WELWYN HATFIELD COUNCIL – DEVELOPMENT CONTROL
DELEGATED REPORT

APPLICATION No:	N6/2010/1275/FP
------------------------	------------------------

The application seeks planning permission for the replacement of windows on stairwell and panels, formation of three ramps on footpath and dropped curb on Block one of Woodside House.

Drawing Title: block 1 - proposed first & second floor

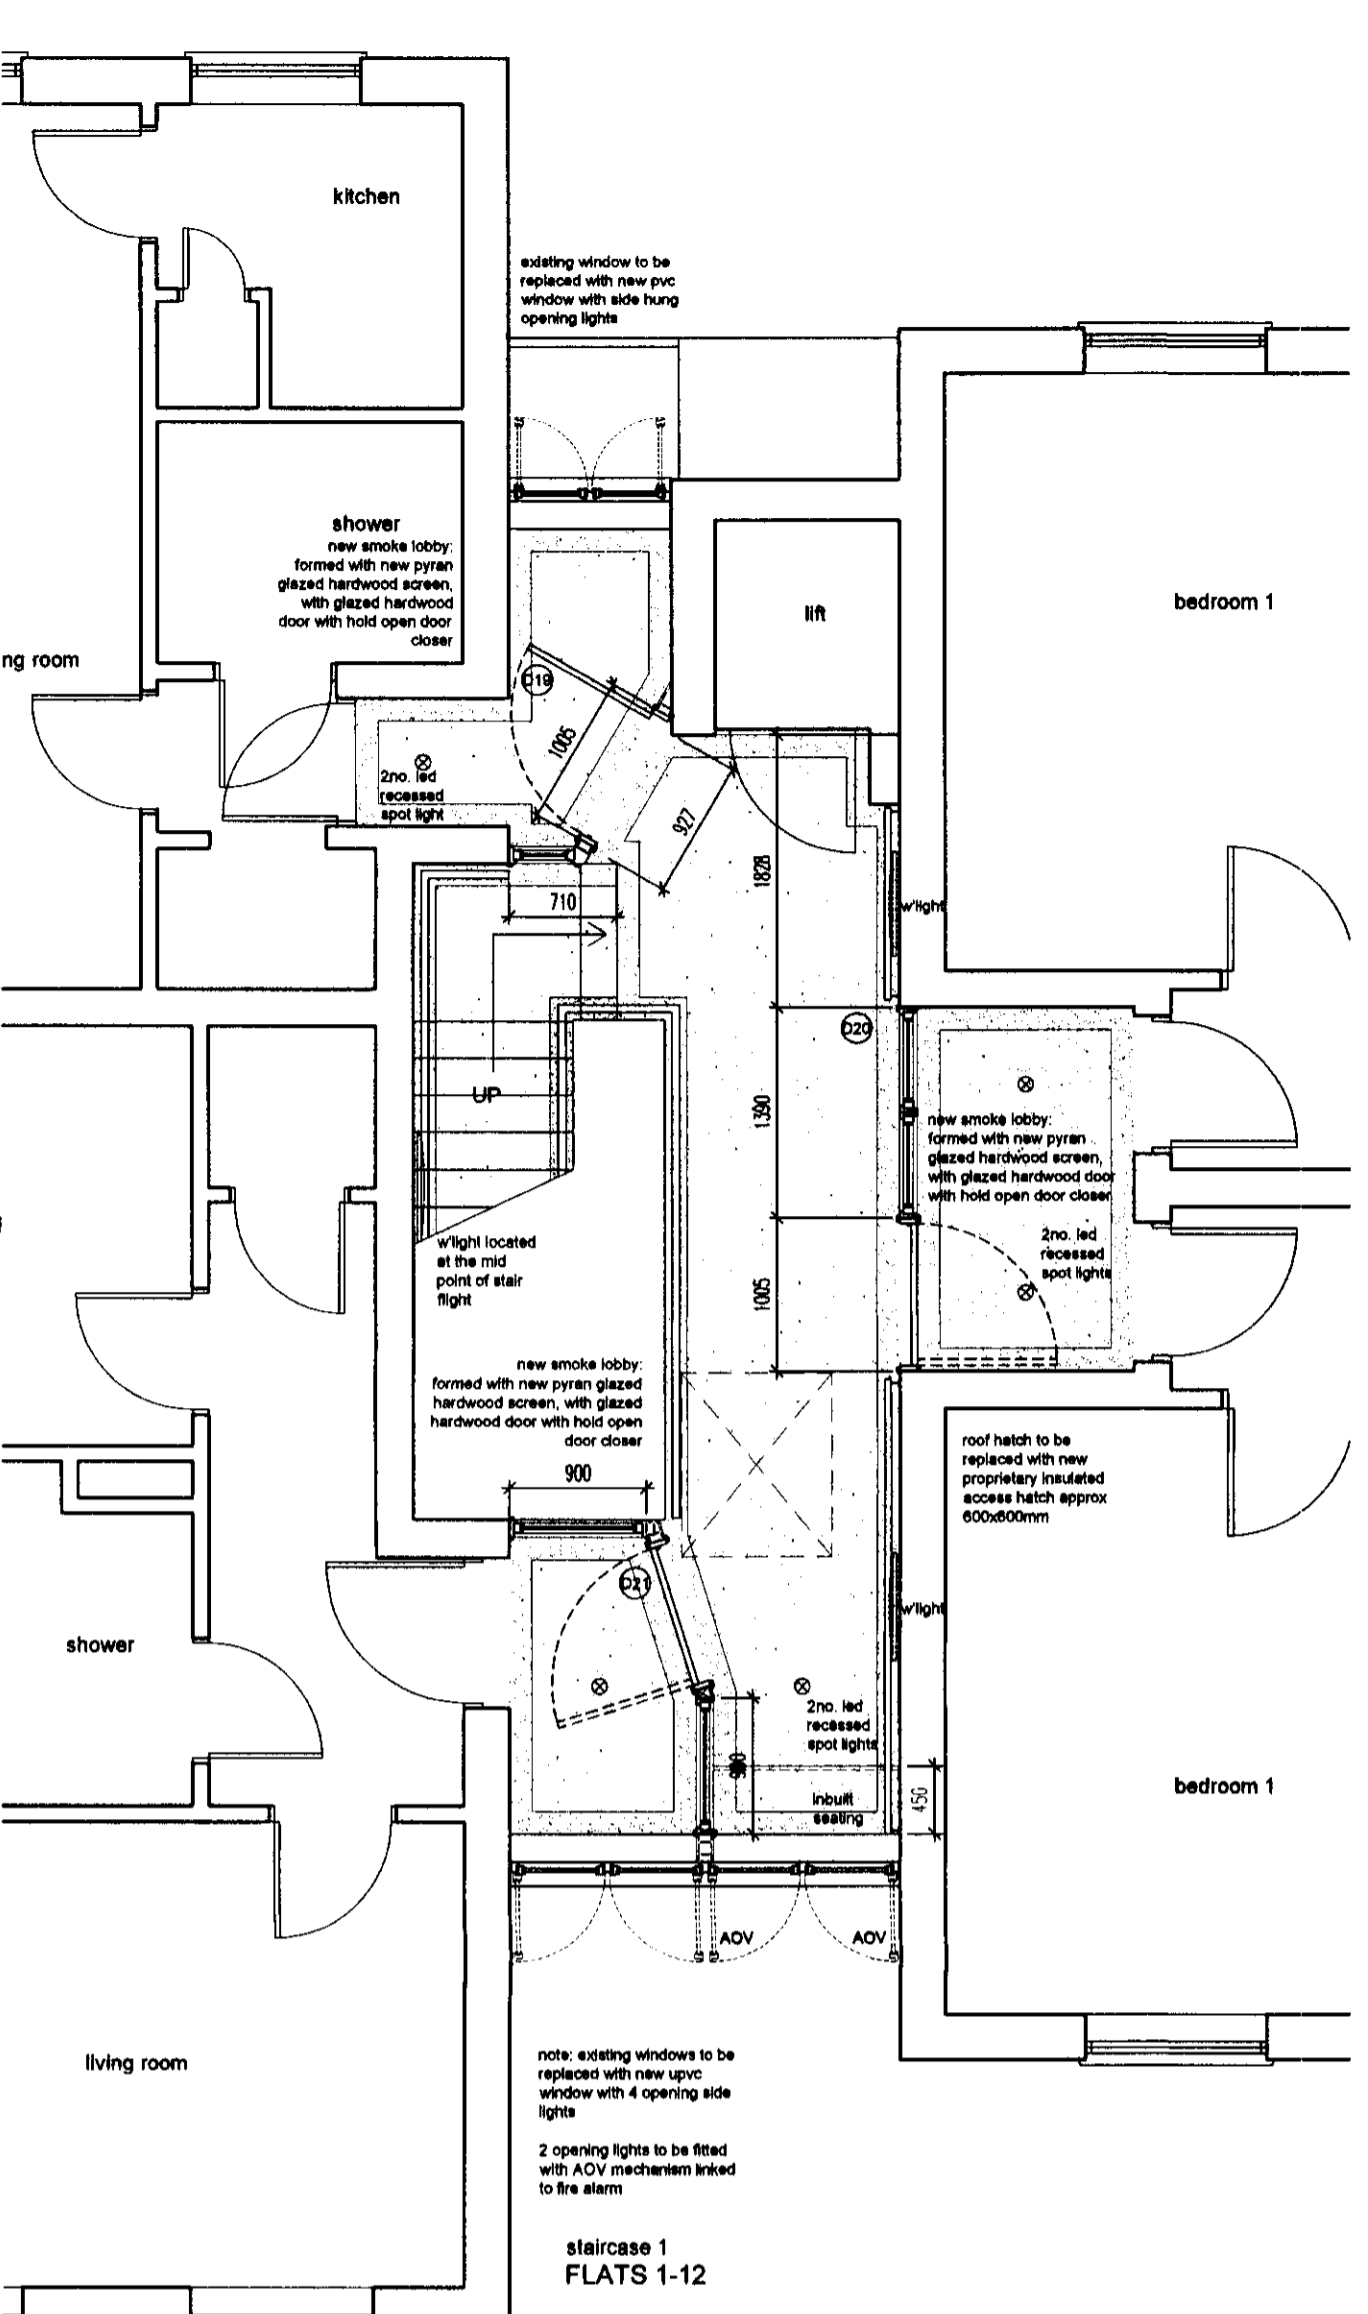
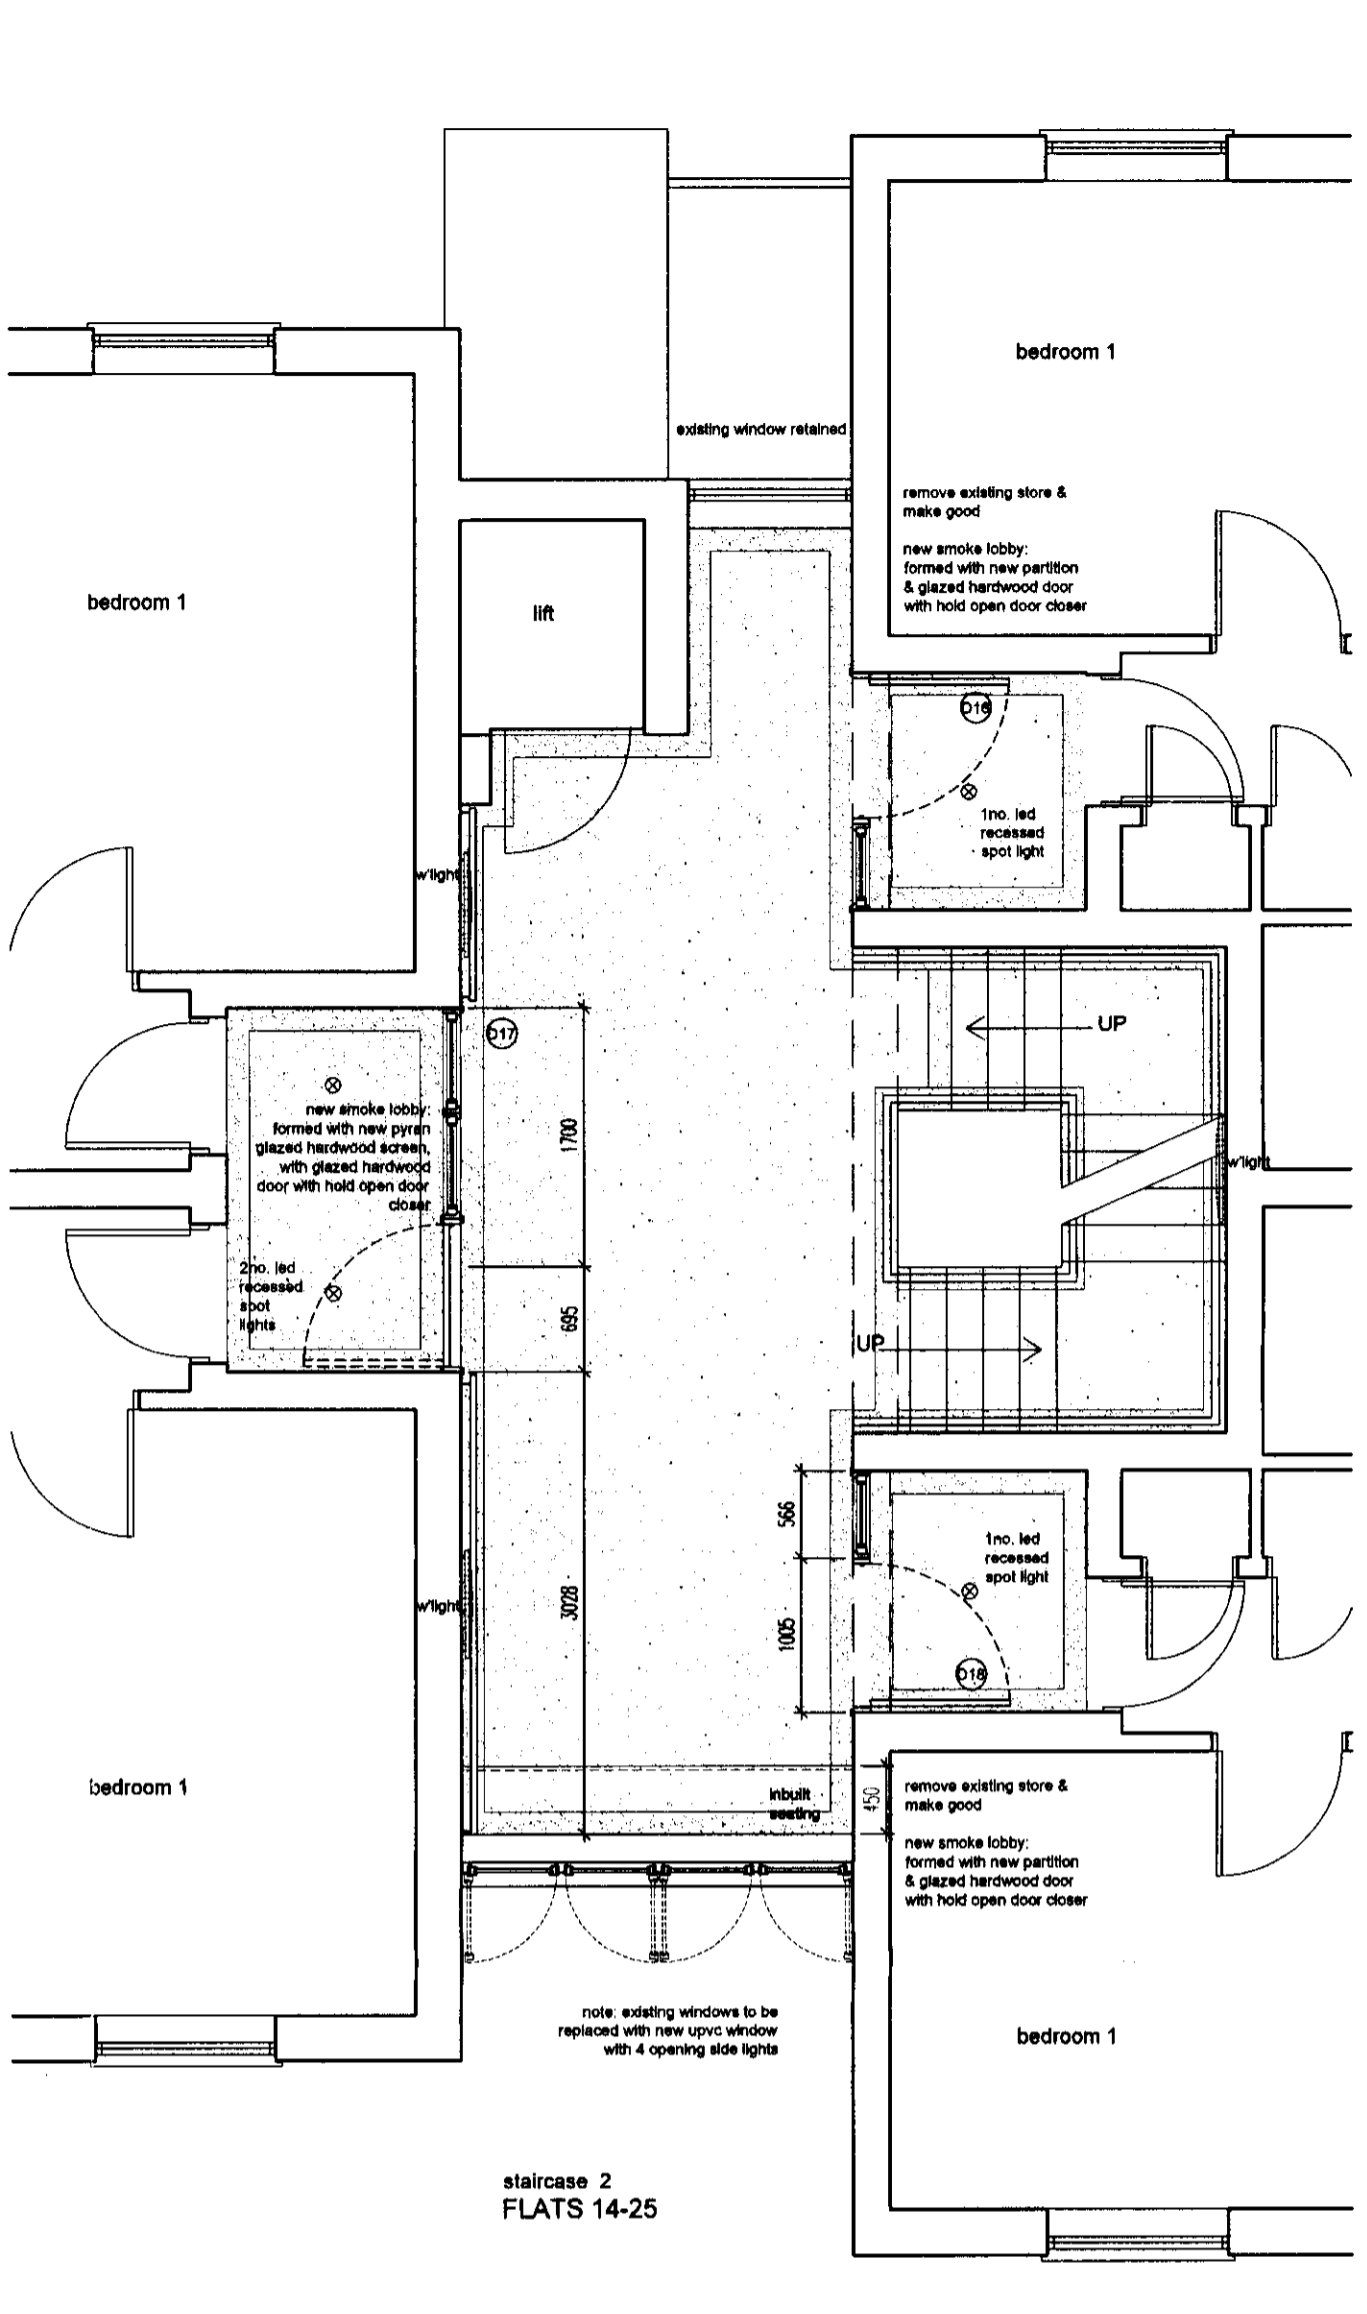
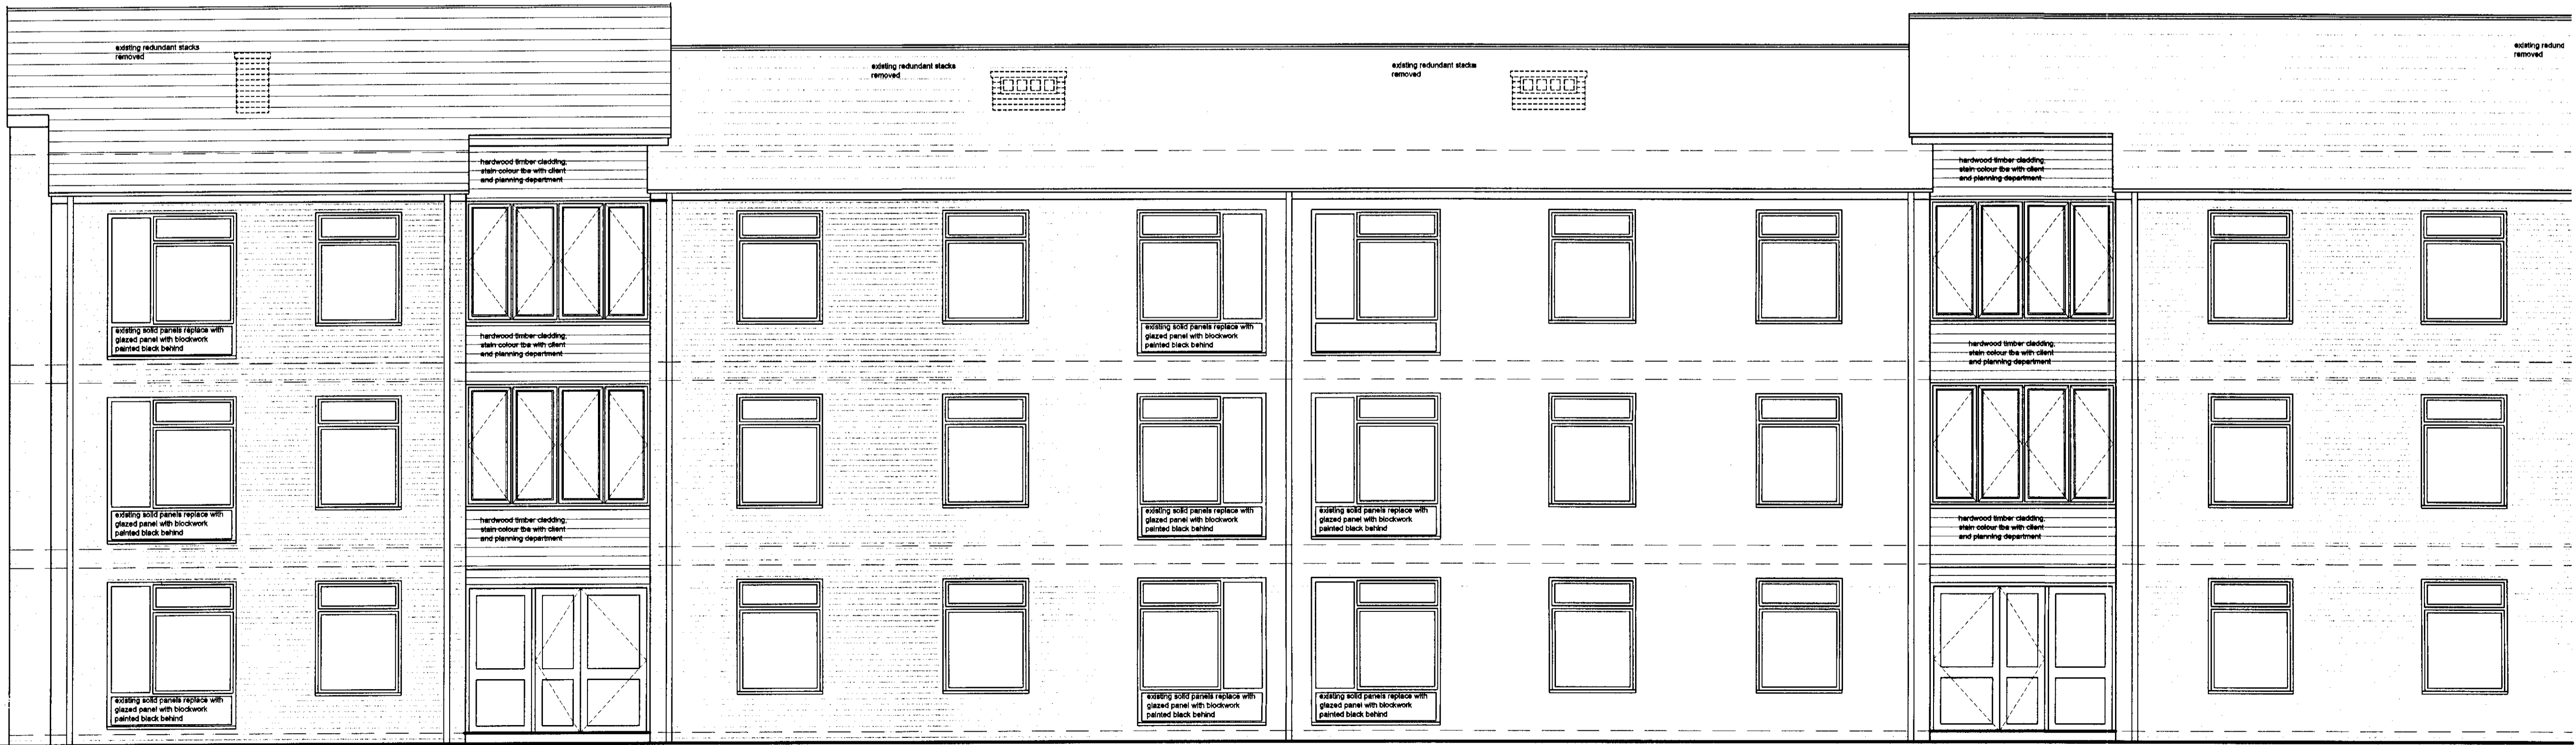
The proposed replacement windows would have four vertical panes which would include the same vertical pane in the large windows found in the building. They would be within the recessed element of the building and would be white uPVC. There is no objection to this as it is considered that it would not adversely harm the character and appearance of the building or the locality.
